Consultation Response from KC,
Ecology Unit

2024/90641 Granby Farm, 20, Woodbottom Road, Netherton, Huddersfield, HD4 7DJ

Demolition of existing shed and out-buildings, reconfiguration of existing drive, erection of detached garage, conversion of existing barn to form one dwelling and erection of single and two storey extensions to existing farm house.

Date Responded: 12/04/2024

Granby Farm, Netherton. Bat Survey Report Addendum – BUILDING PLAN¹

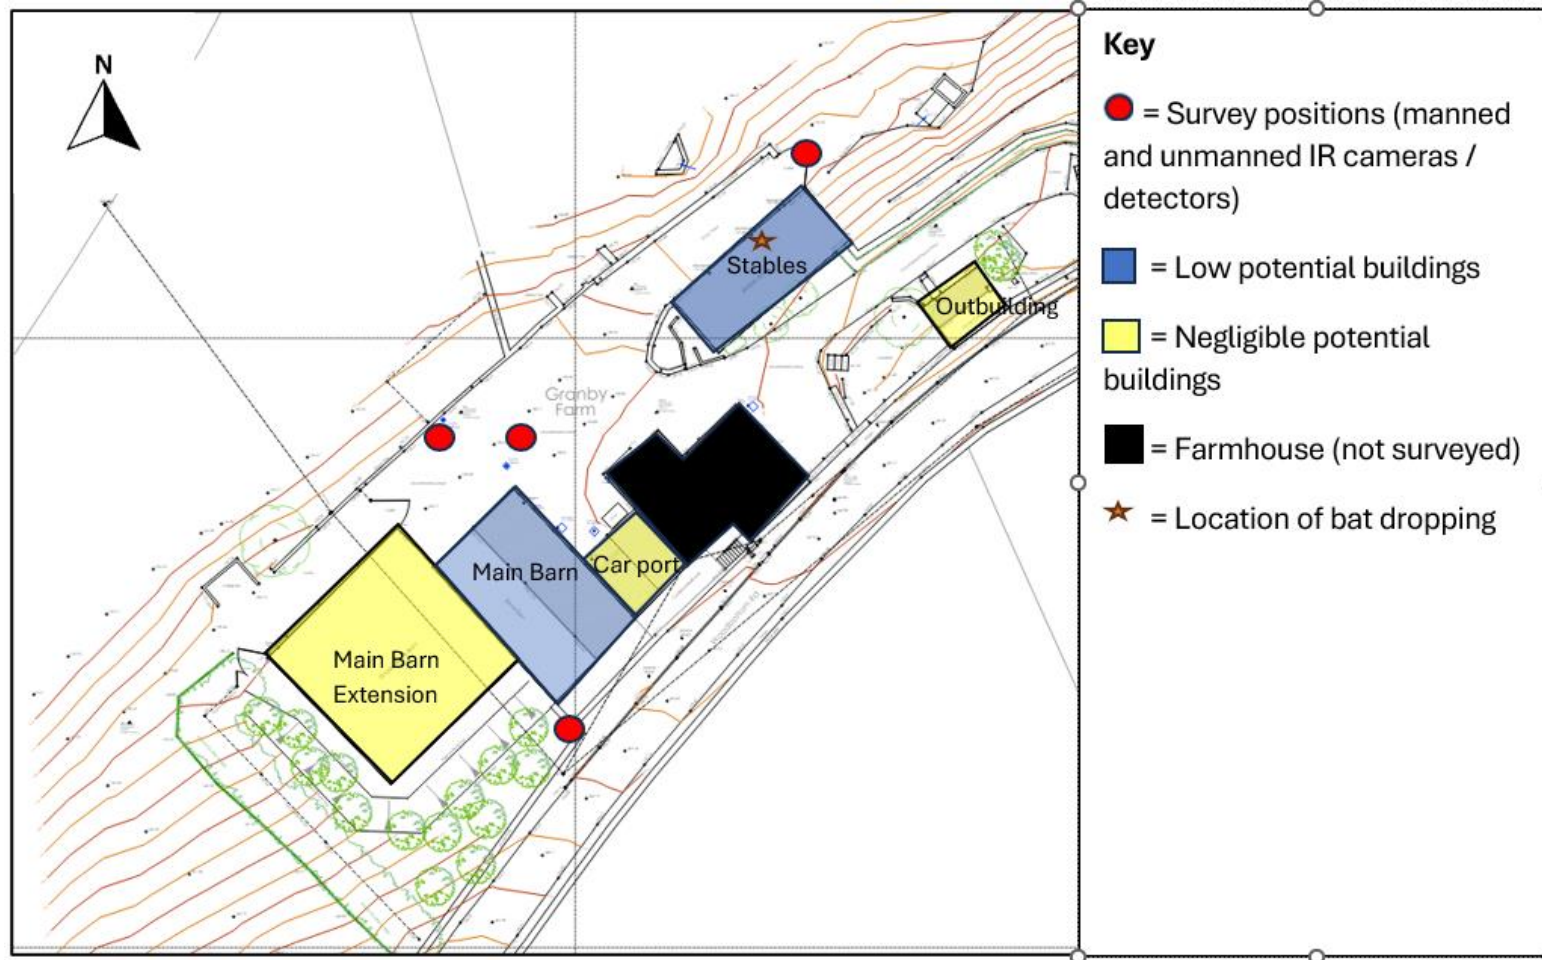
No plan has been included with the submitted report therefore I am unable to determine the locations of the buildings at the site. The report should be updated to provide a plan that clearly annotates the buildings at the site. In addition to the above, given that nocturnal surveys have been carried out at the site, a plan showing the surveyor locations along with the locations of all potential roosting features along with the bat dropping should also be provided.
